Re: Planning Application BR/82/22 PL
To the rear of "Holmlea",
Town Cross Avenue, Bognor Regis, PO21 2DN

I would like to object to the above planning application for the following reasons:

Proposed Apartments
Planning

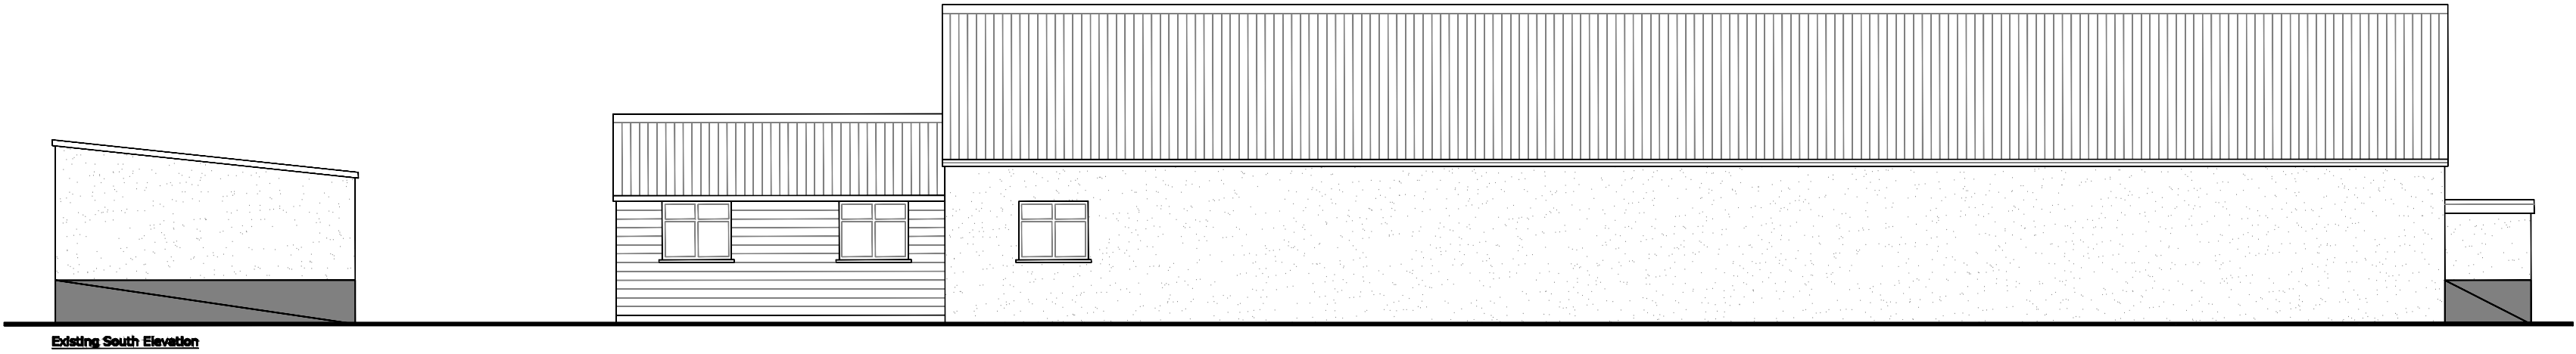
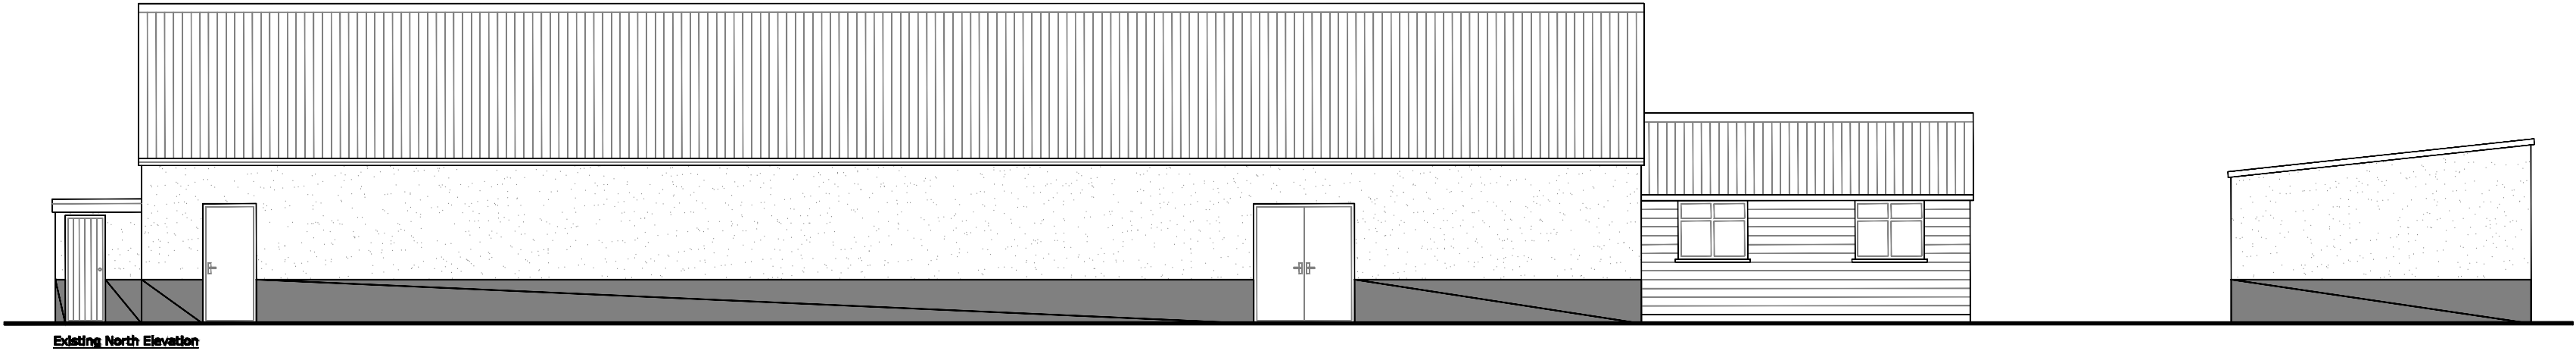
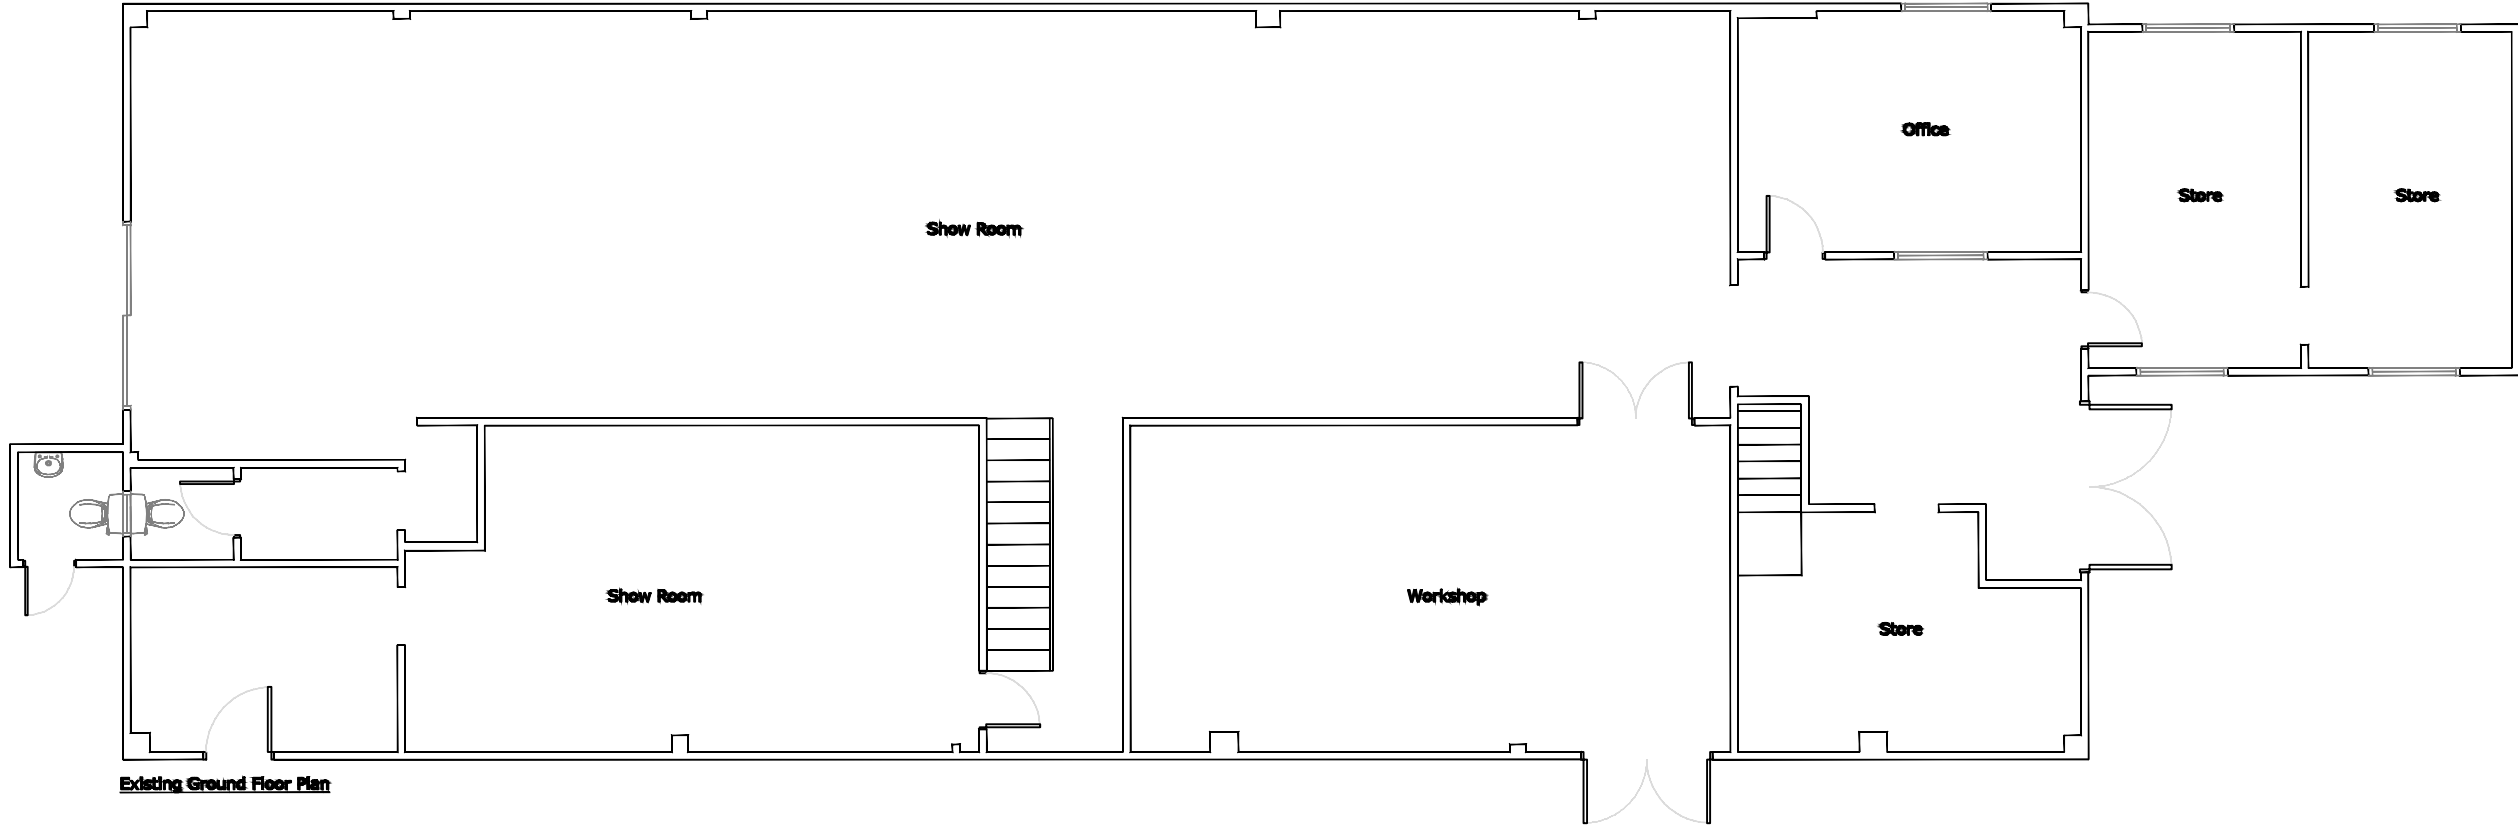
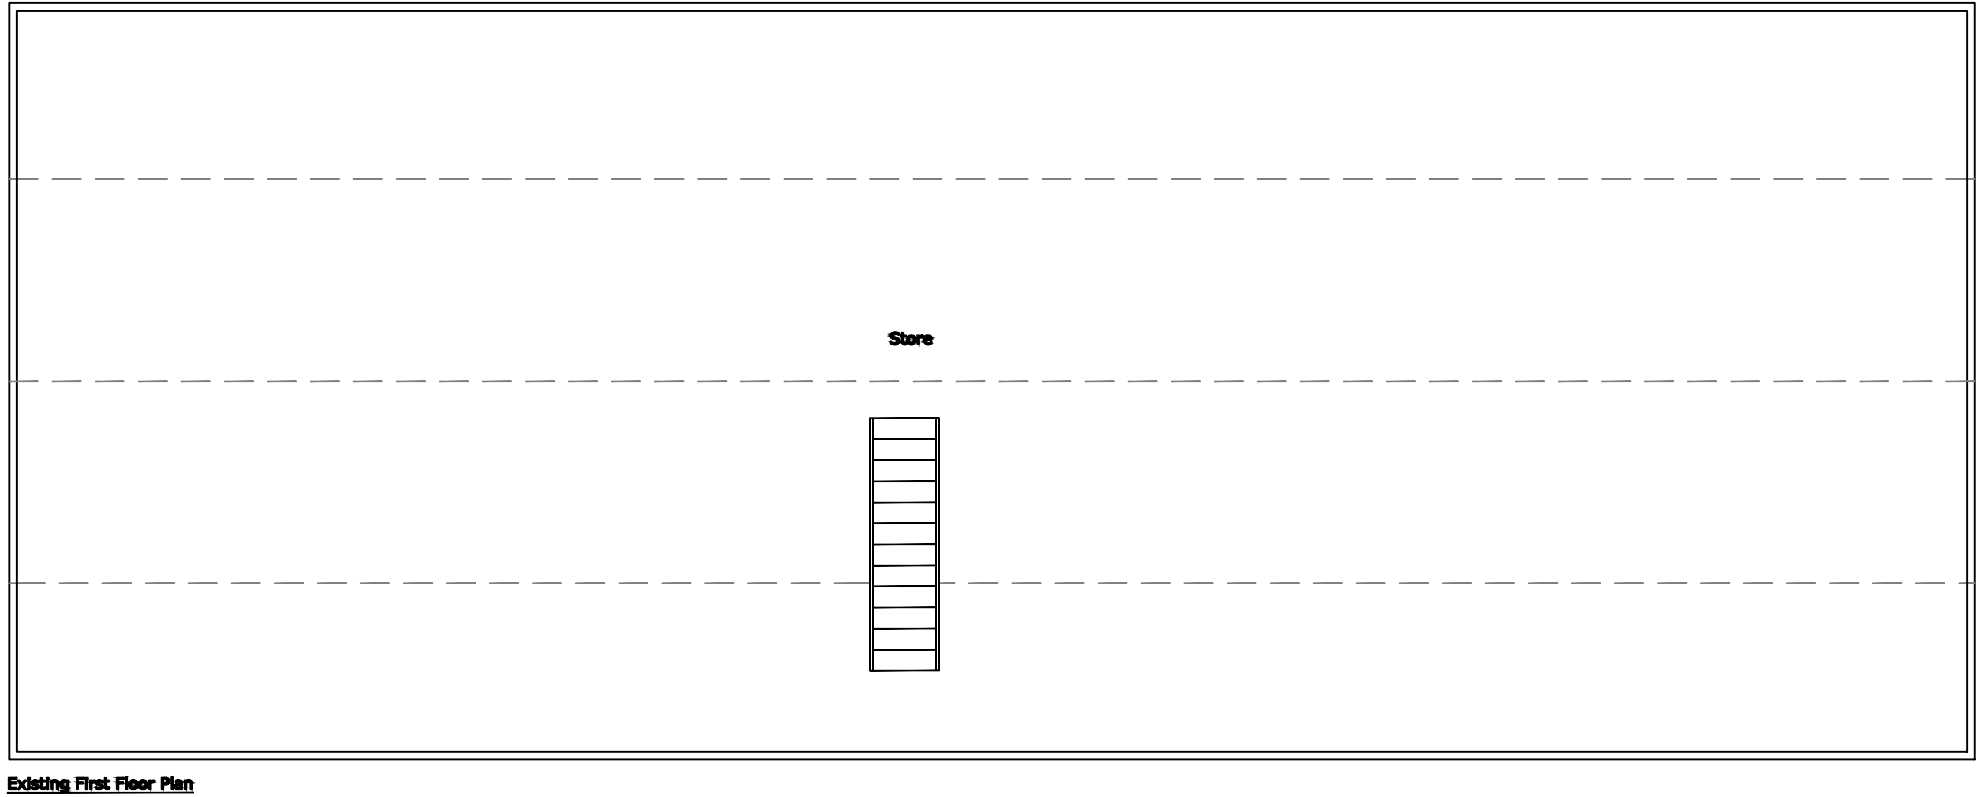
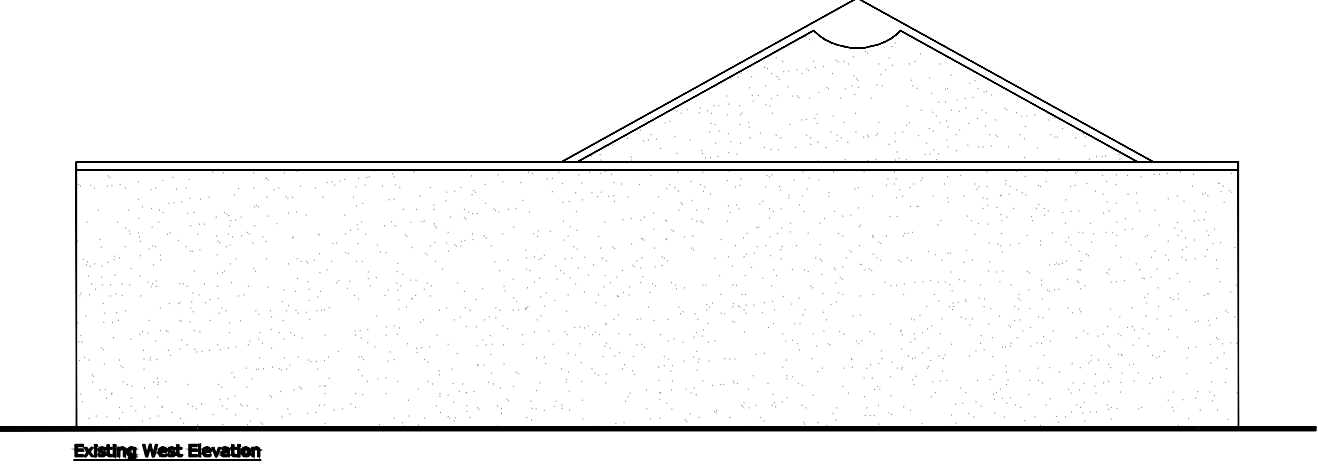
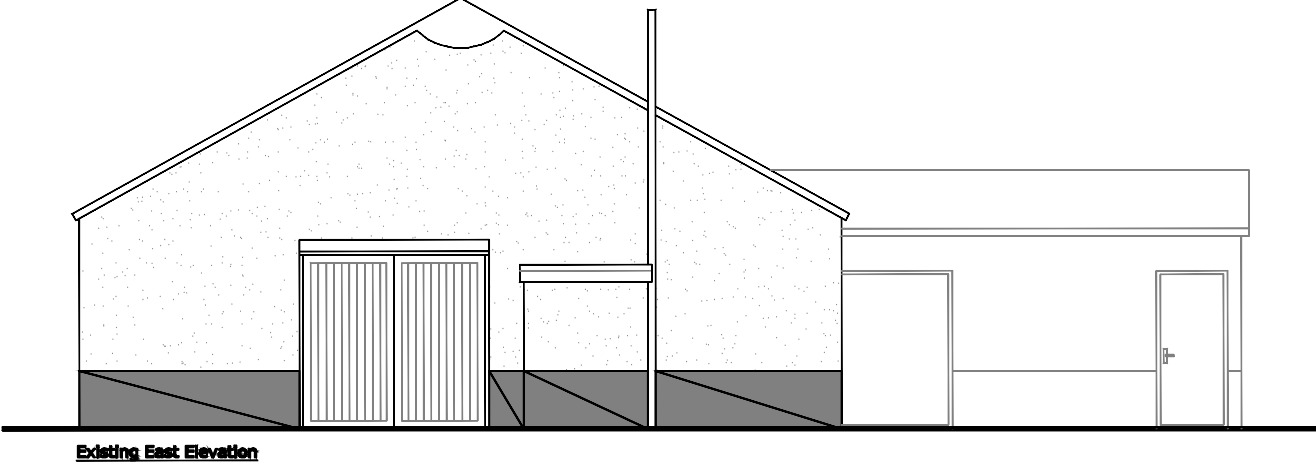
I see on the plan/elevations space for eight vehicles to park. What of the other two residences?

I realise that there has been some attempt to show where emergency vehicles would enter/exit but does the architect realise that West Sussex Fire Brigade uses aerial appliances which have to use outrigger/stabilizers to remain safe when used at height? This doubles their width. I see no indication of this allowance on the plan. The "tram lines" of an emergency vehicle's movement have already been cut to the bone, to the point at which I think a fire hazard exists. Look at the difference in width of the Halsom Close approach lane and that of the proposed new site. It only takes one un-attended large van to park in the proposed site's approach lane and not only all emergency vehicles are denied access, their crews are as well!

I believe the previous owner of this site had applications for four dwellings refused and I don't see why an application for ten apartments should succeed. The adjacent site (Halsom Close) has seven dwellings but is about 50% bigger, so the over-crowding/over development factor is again evident. On the plans I see three storeys; this is unusual for the area and apart from being radically different

3/
from buildings nearby it will lead to buildings nearby being overlooked in a way that they have not been since they were built about 100 years ago.

On a more humane and mundane level, I see no space for residents of the proposed buildings to have for recreation/relaxing. I'm not talking of tennis courts; I mean a place to sit in the sun that isn't part of a tarmac road.

Where will the residents' wheelie-bins go? I see there is a small space right at the North end of the site with the cynical addition of three or four trees; it's almost as if the architect gave a second's thought to the environment.
